From: Michael Eastham
Sent: 17 November 2017 15:36
To: Planning.Responses
Subject: FW: BE/102/17/OUT

Further to the comments/queries raised by the EHO, please see comments in red below and attached.

1. The report only deals with noise in detail for Unit 2 and whilst I understand this because the application is for full permission for Unit 2 and outline for the rest of this site, I have concerns that there may be cumulative noise impacts as unit 1, 3, 6 and 7 also either be B1/B8 use and they may have associated HGV movements. I am concerned that any cumulative noise impacts have not been taken into account at this stage and wants out my permission has been given may not be fully resolvable at that point. But the applicant confirm whether they have taken this into account or not?

2B: With Acoustic Barrier L_{AMAX}

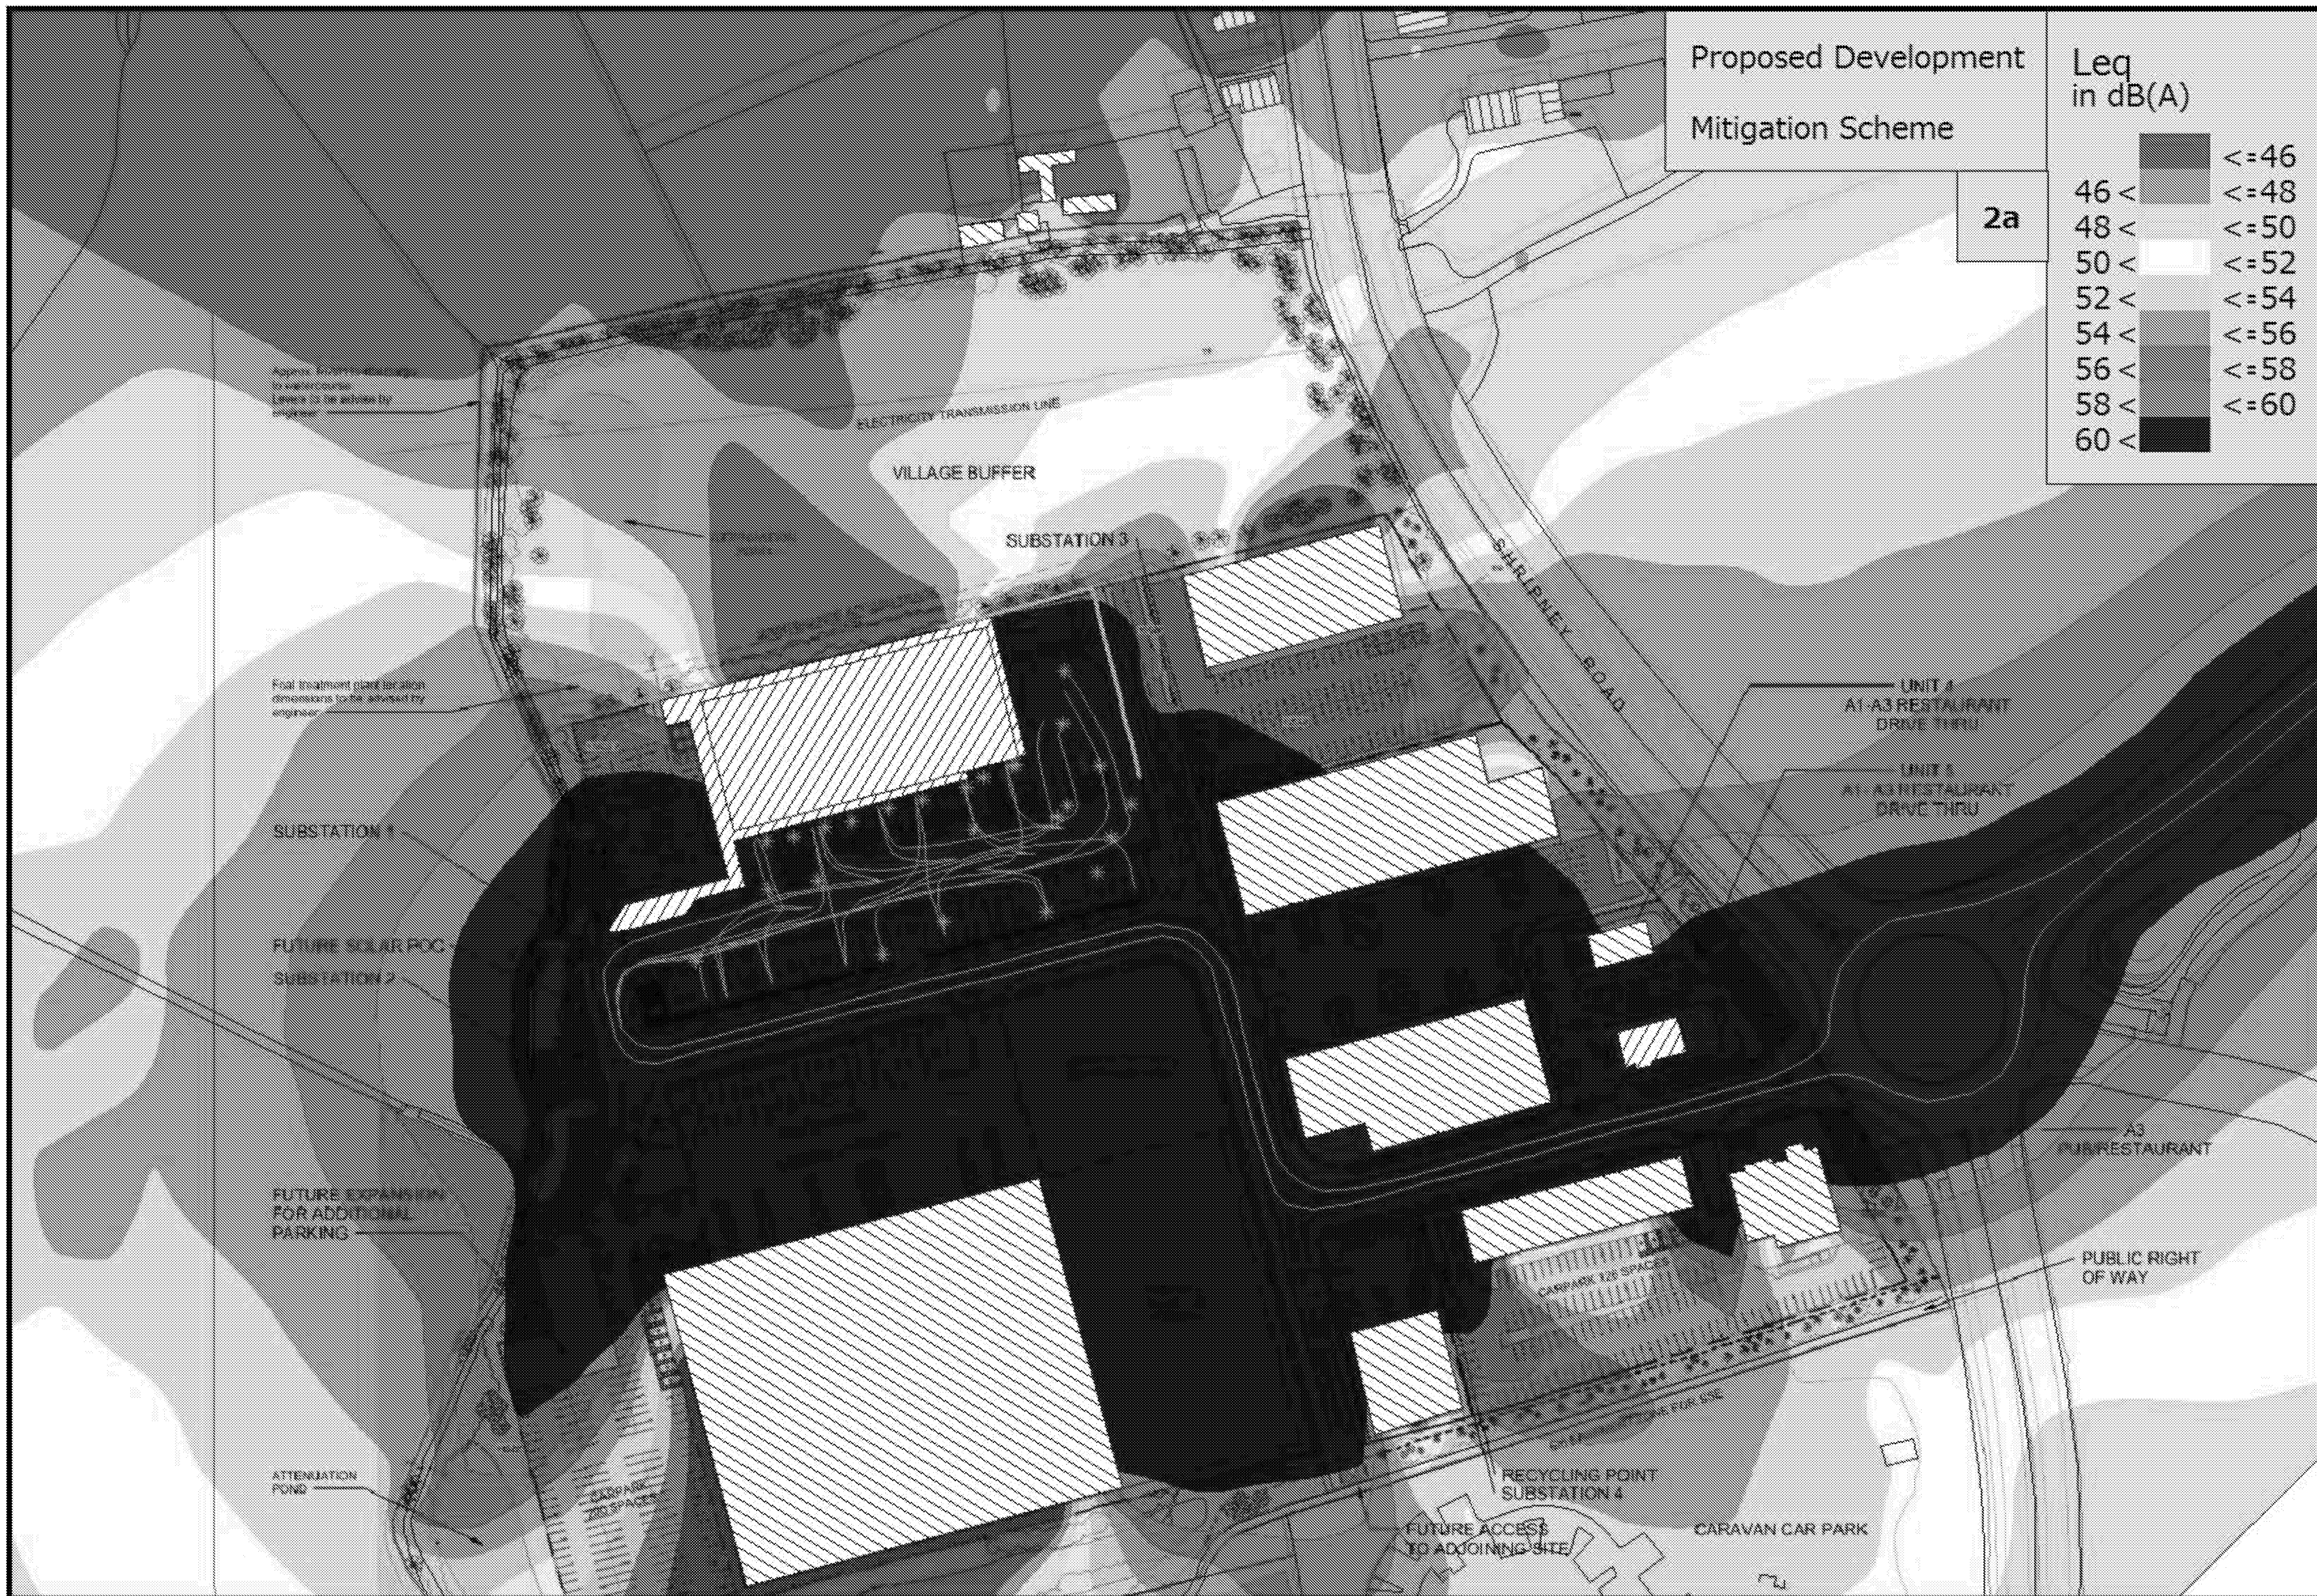
2. Please could the applicant confirm how many van and HGV movements there are likely to be in an average day time and an average night time? I appreciate that they have used data from many years worth of experience in similar situations, however surely the intensity, or not, of use will have a bearing on the resulting noise levels. For unit two I would like to know what proportion of the movements are likely to be at night time rather than daytime.

3. The report details “at the nearest noise sensitive premises”. Does the applicant mean at the facade of the nearest noise sensitive premises or do they mean at the boundry of the nearest noise sensitive premises?

4. Paragraph 4.5 on page 12, just to clarify, “all loading bays“ means all loading bays in unit two presumably?

Unit 2 was assessed as the only full application. There is no detail relating to the future use of other units, although the assessment was modelled using worst case of all loading bays being operated simultaneously. Any future HGV movements across the site would need to double to give a 3dB increase. Even with this unlikely level of activity the L_{Aeq} levels at the nearest residential property to the north would be in the region of 51dB and still be within desirable WHO guidelines for external noise. Any L_{Amax} levels would be consistent with predictions.

The proportion of day/night movements are not known at this stage and would be operator led. The predicted modelled levels use worst case scenario of all loading bays operating simultaneously at full capacity to provide robust assessment

SoundPLAN™ modelling software predicts to the façade and takes this into account.

All loading bays in Unit 2
